Meeting note

Project name	East Midlands Gateway Phase 2 and East Midlands Gateway Rail Freight Interchange Material Change
Case reference	BC0410001 and TR0510002
Status	Final
Author	Planning Inspectorate
Date of meeting	30 September 2025
Meeting with	SEGRO Properties Ltd and SEGRO (EMG) Ltd
Venue	Microsoft Teams
Circulation	All attendees

East Midlands Gateway 2 DCO application

Section 51 advice for applicant relating to documentation as to submission dated August 2025

Drawing Title
**ILLUSTRATIVE
LANDSCAPE
MASTERPLAN**

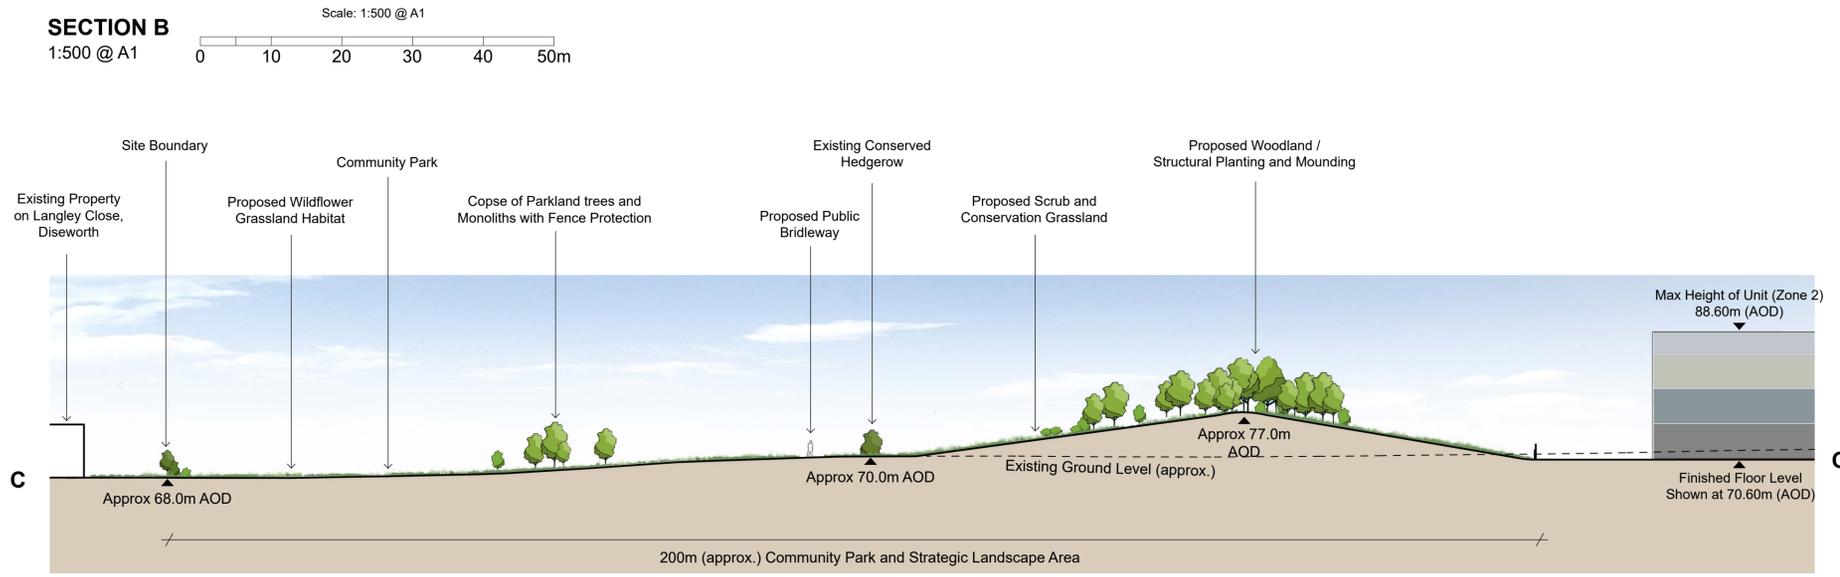
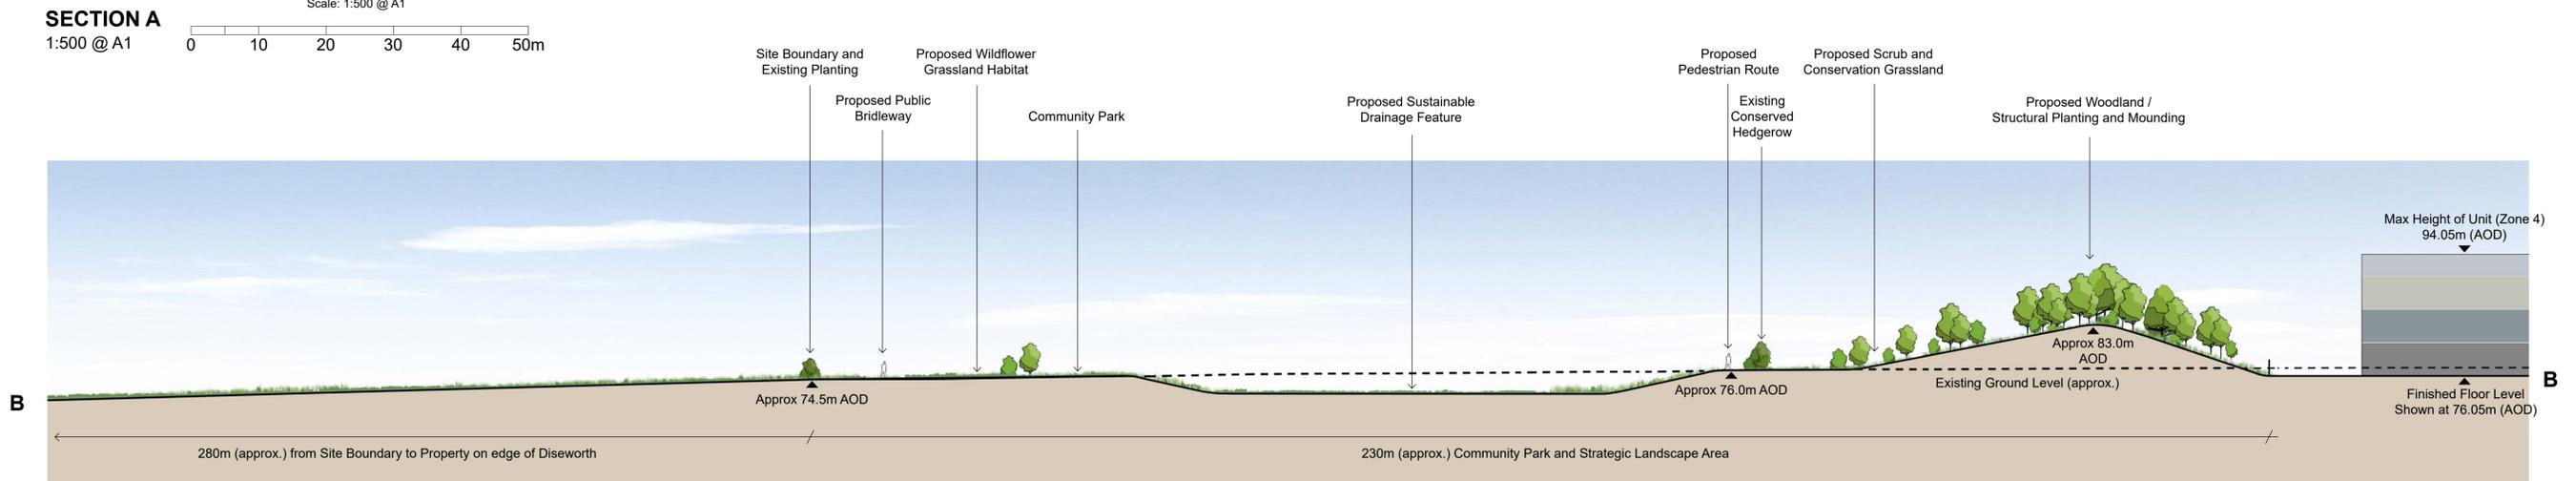
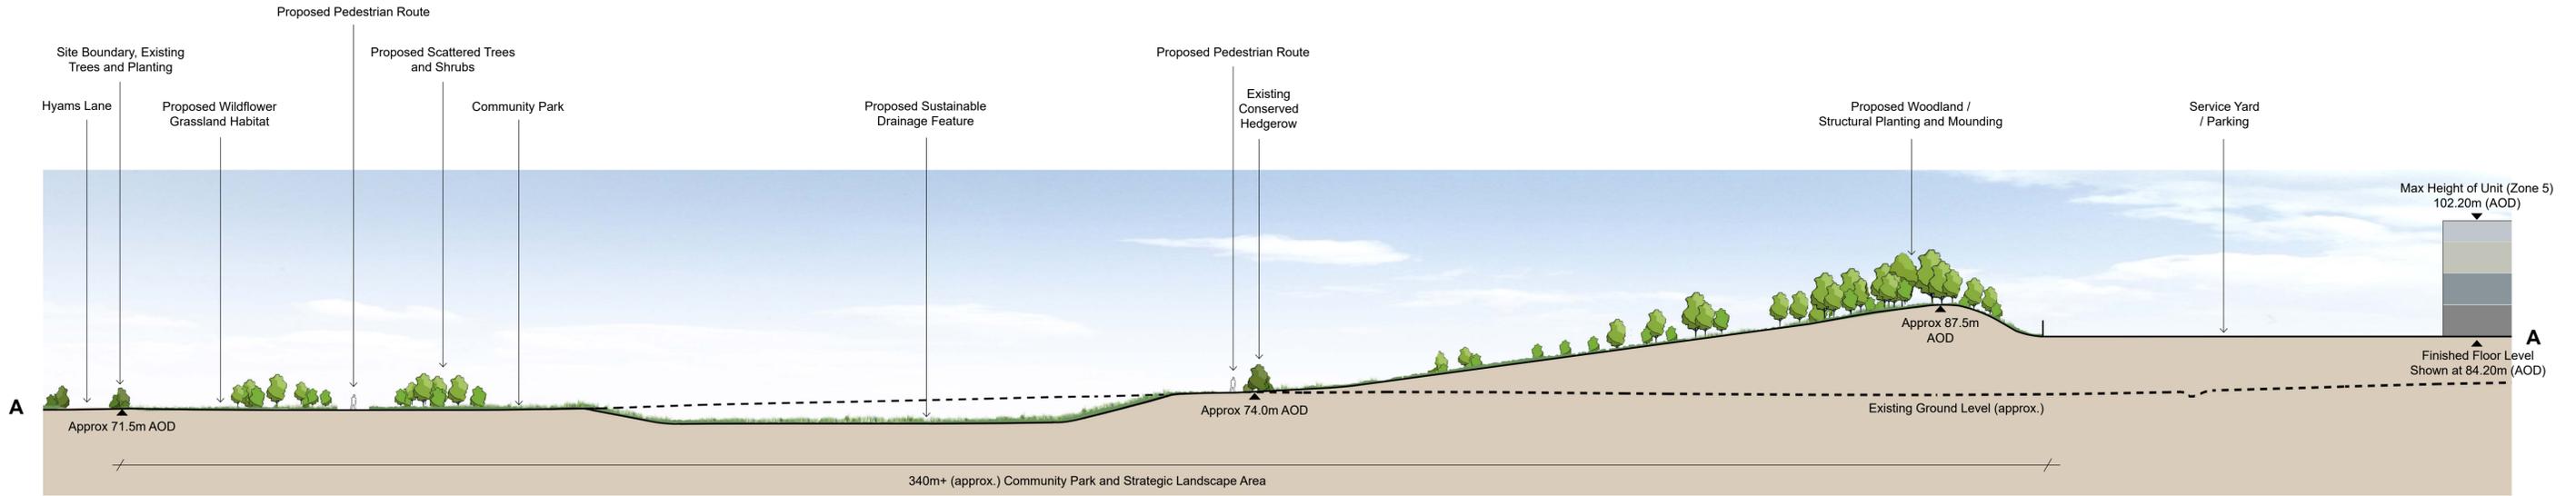
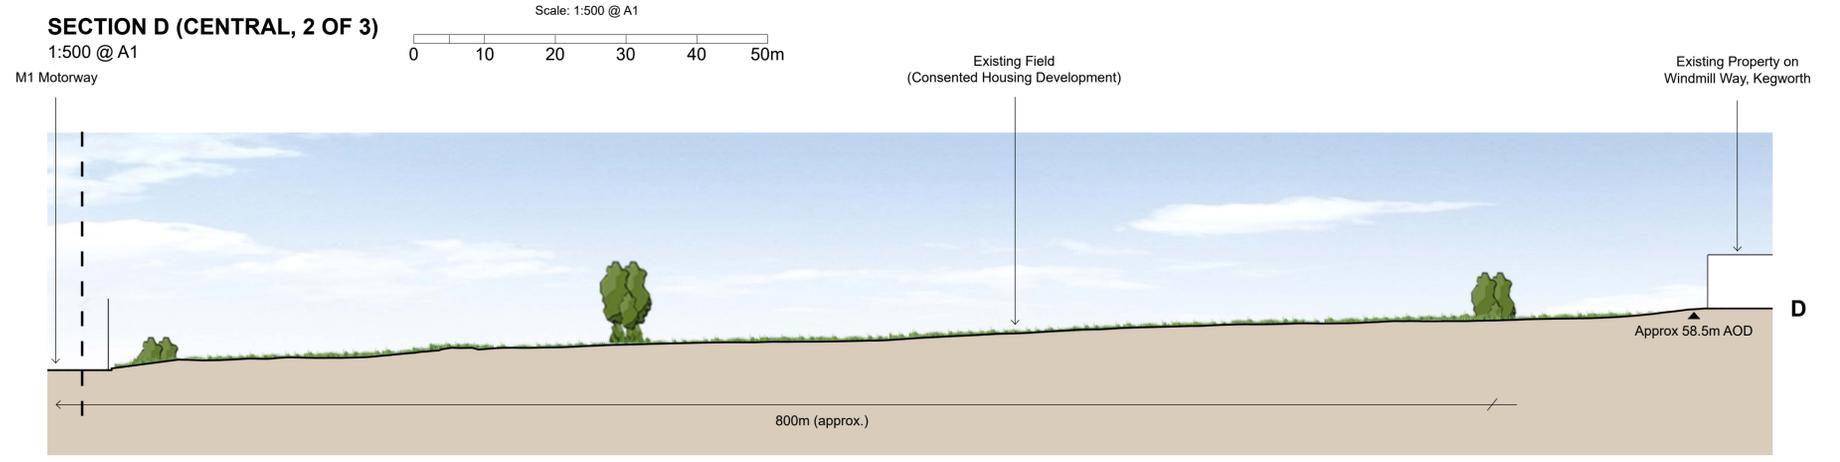
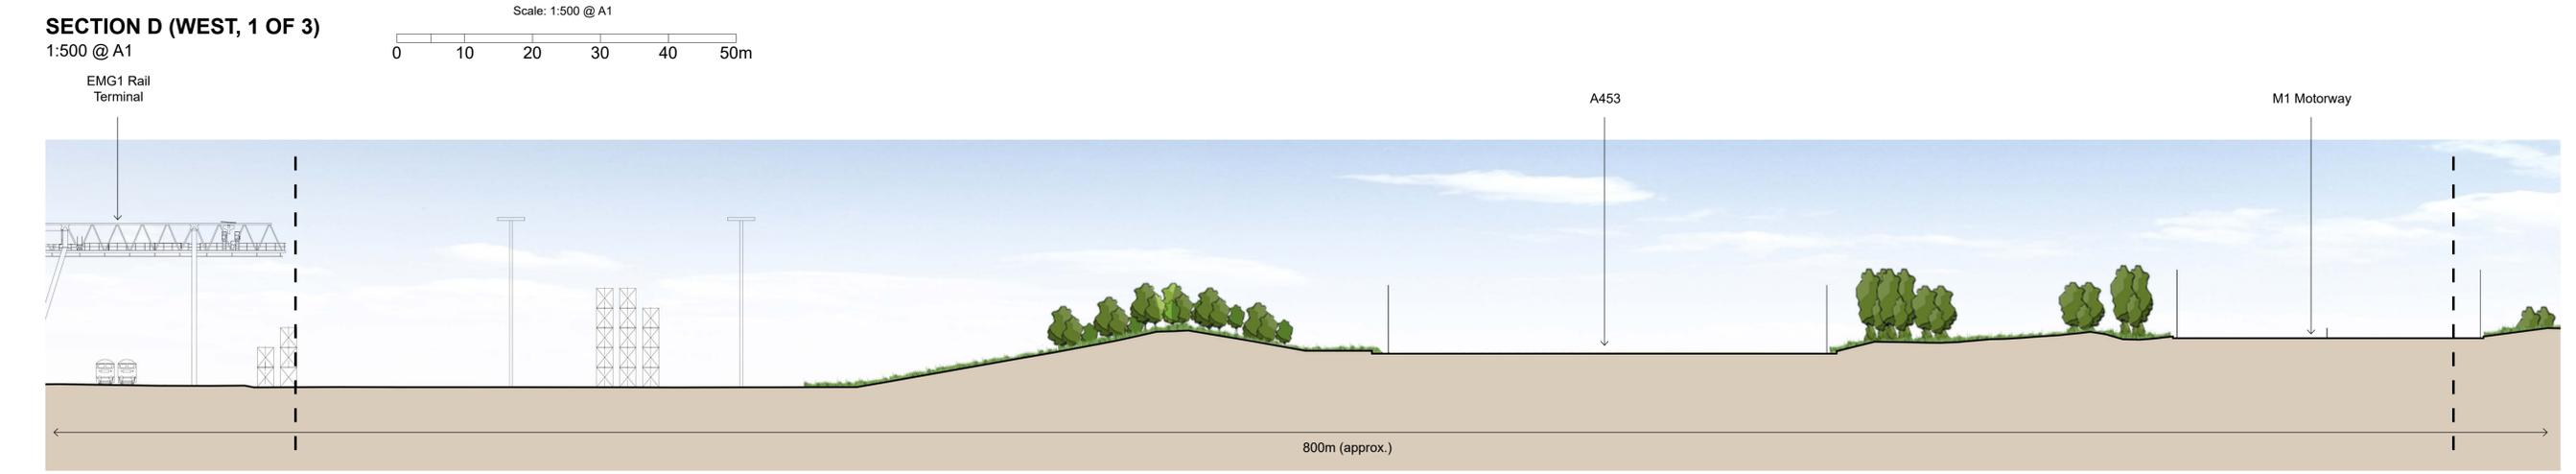
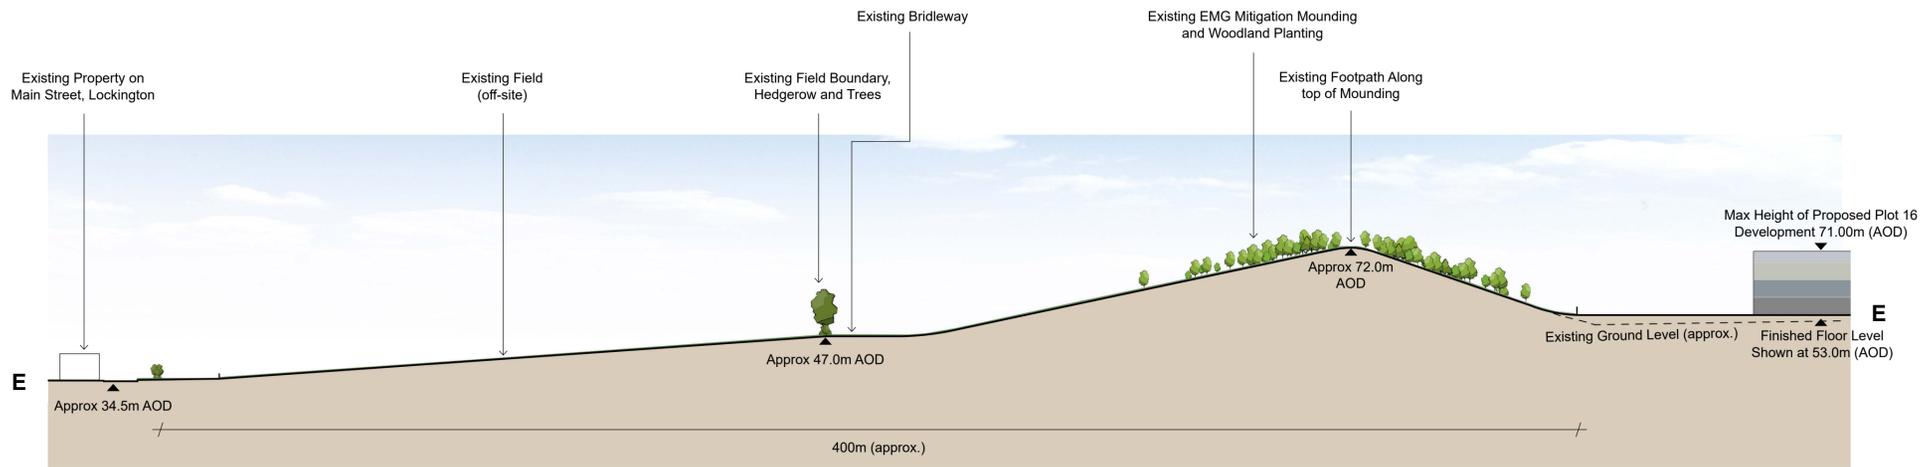
The applicant noted the Inspectorate's observation on the lack of certain site sections and night-time photomontages.

The applicant stated that nine images showing cross sections were included with the application in ES Appendix 6.10D (Illustrative Landscape Masterplan and Cross Sections) and asked if the Inspectorate could clarify what further images are required.

The Inspectorate acknowledges the documents provided in Appendix 6.10D and draws attention to the annotated drawing at the end of this document, which was provided after the meeting. Whilst two of the additional proposed sections depicted in the annotated drawing (shown in red) are in a similar location to the sections provided in Appendix 6.10D, the location of proposed additional sections extends further at either end of the proposed site. The Inspectorate stated that all sections should be at the same scale and for cross sections D and E to be produced at 1:500. The Inspectorate considers the night-time photomontages from both distant views, particularly high ground to the south, and closer views from Diseworth would be particularly useful. This should ensure assessment of occasions when there is significant water vapour in the atmosphere, for example, fog and mist.

The applicant stated that night-time photomontages would be provided and the Inspectorate agreed that these could be made available after acceptance and before examination
